Re: Status of Improvement Permit Application #05-5-11716

On April 18, 2005, an Environmental Health Specialist from the Harnett County Health Department attempted to evaluate your property for the purpose of issuing an Improvement Permit. This individual was unable to evaluate your property for one or more of the following reasons.

SITE PLAN APPROVAL
 DISTRICT RA40 USE SFD
 #BEDROOMS 4
3/22/05 PJK
 Zoning Administrator

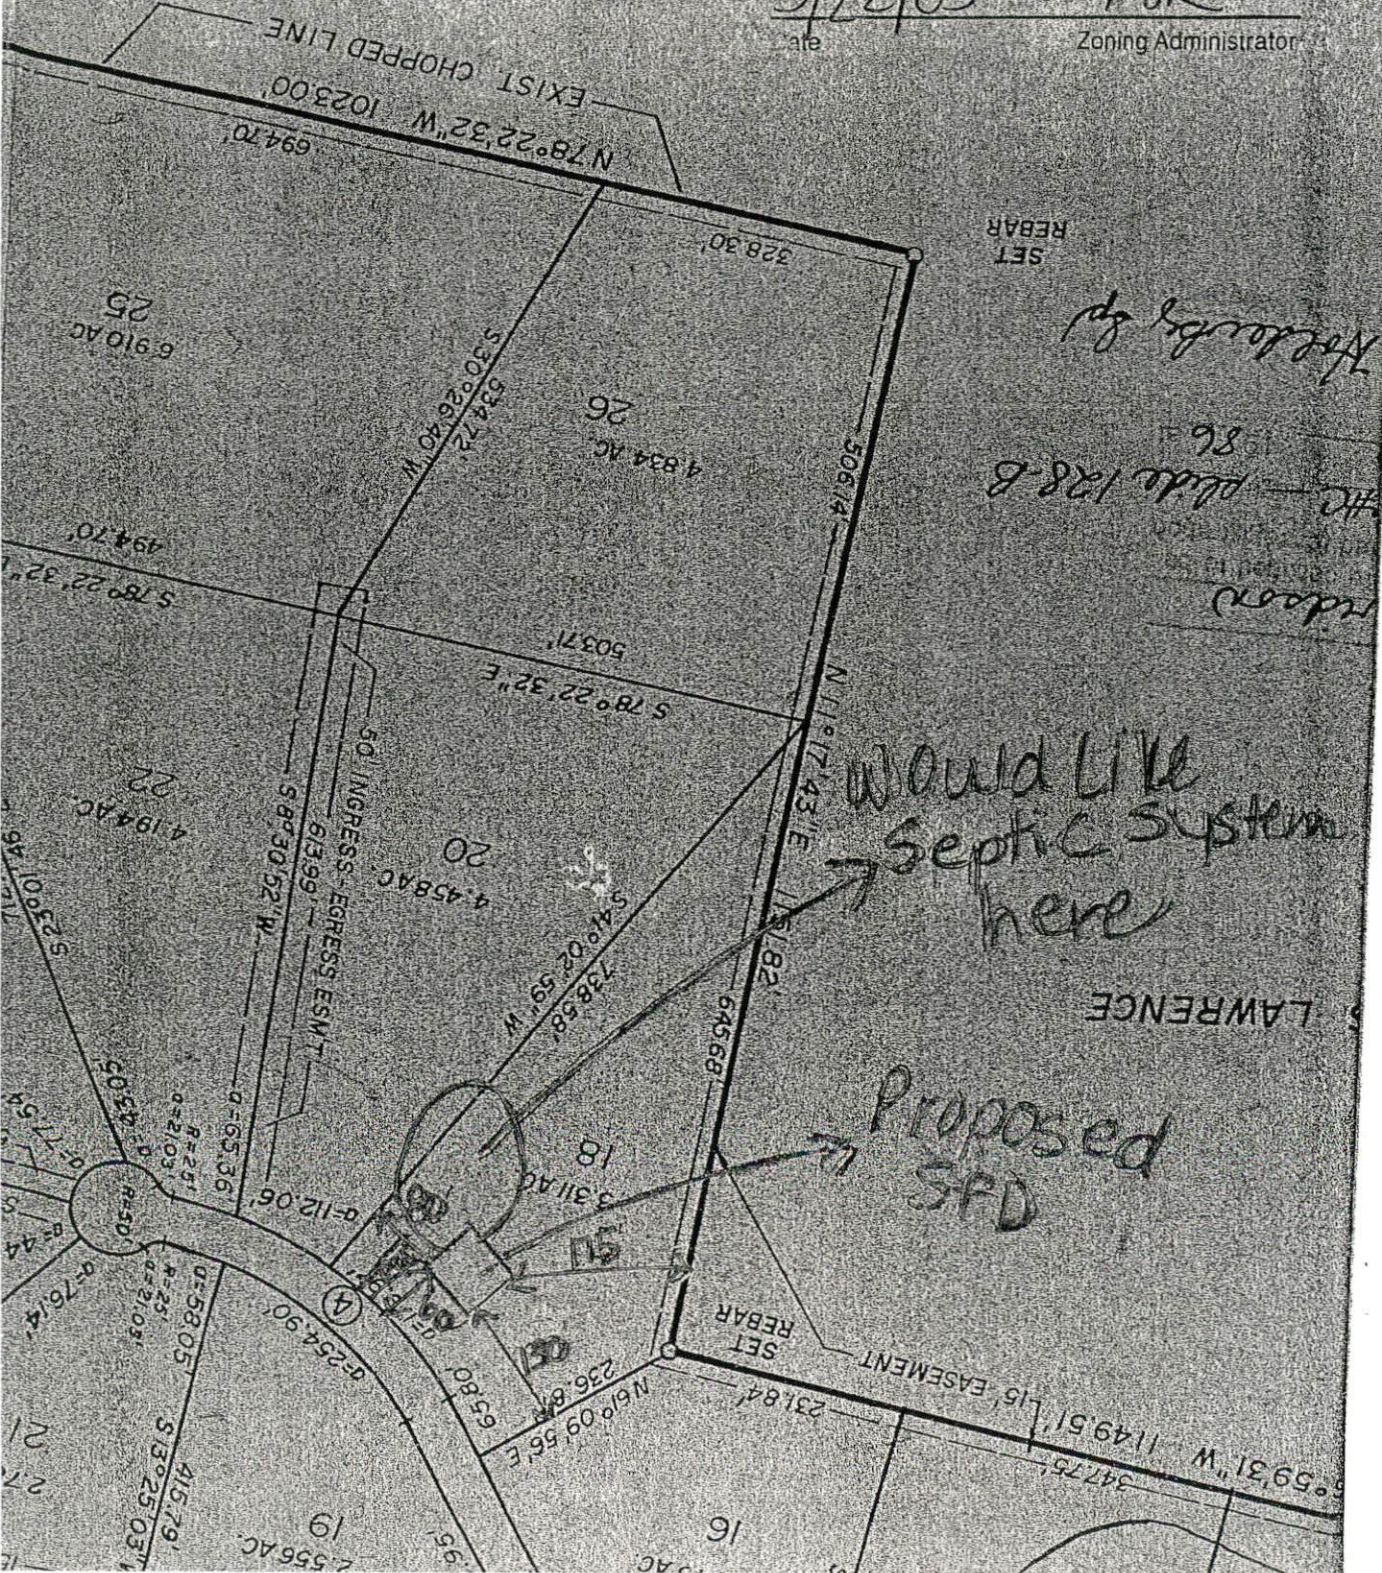
- 1. Property lines/corners not marked or labeled
- 2. House corners not marked or labeled
- 3. Directions not clear to property
- 4. Property needs brush or vegetation removed
- 5. Backhoe pits required
- 6. Other **House needs to be moved to 90 feet from the left side property line. A revised site plan needs to be submitted to the Central Permitting office.**
